RE: Milton Street Subdivision

On February 8, 2000 the Portland Planning Board voted 6-0 (Rodriguez absent) on the following motions regarding the 11 lot Milton Street subdivision:

TO: Rick Knowland, Senior Planner
FROM: Jim Wendel, PE, Development Review Coordinator
DATE: August 24, 1999
RE: Site Plan/Subdivision Review
Milton Street Phase
Woodfords Gardens, a.k.a. Forest Avenue Terrace-dated 1910

Re: Milton Street Subdivision
Review Comments

TYPICAL LIGHT POLE DETAIL

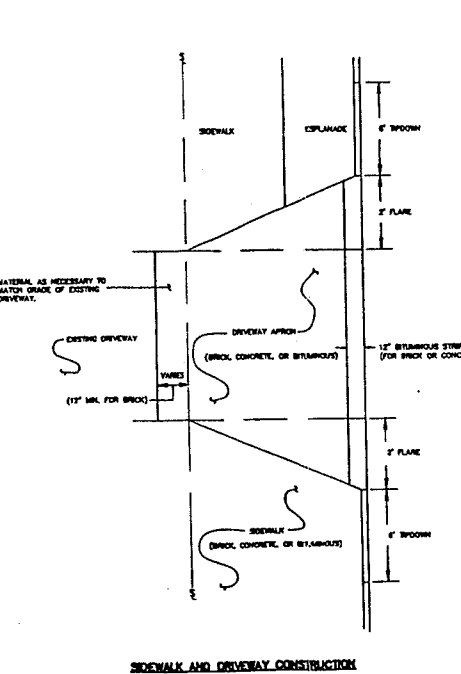
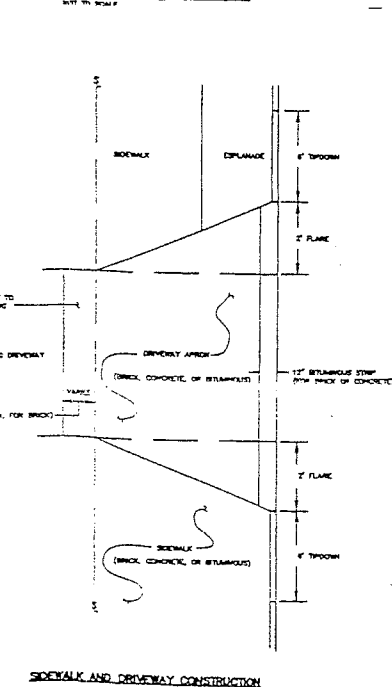
Comment 3 –Technical standards require a street light pole at 120 foot intervals. You are proposing them at 200 foot intervals.

Response –The enclosed full sized Road Plan/Profile for Milton Street has been revised to show 120 foot space intervals for the street light poles.

RESIDENTIAL STREET CROSS-SECTION

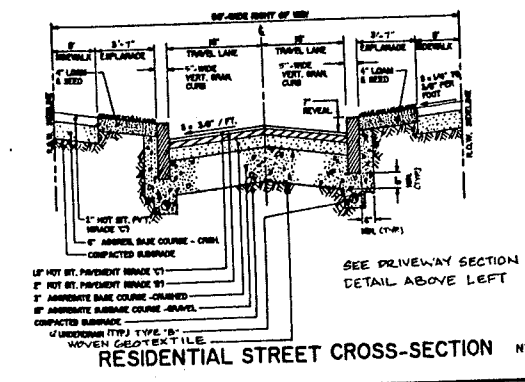
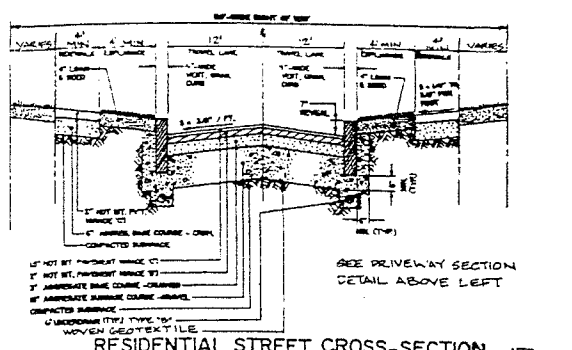
Comment 1 - A recording plat and subdivision needs to be submitted reflecting the latest changes. A street cross-section will need to be on the recording plat.

Comment 2 -The plan needs to be revised reflecting a 24 foot wide roadway pavement.

Response - A revised recording plat is enclosed with this letter, reflecting the latest changes and a typical street cross-section.

Response - Land Use Consultants is in the process of revising these plans and they will be forwarded to your office upon completion. It would appear that this project could be scheduled for the public hearing, and that any necessary revisions to these plans to address comments from Public Works could be a condition of approval. This approach has been used on other projects in the City.
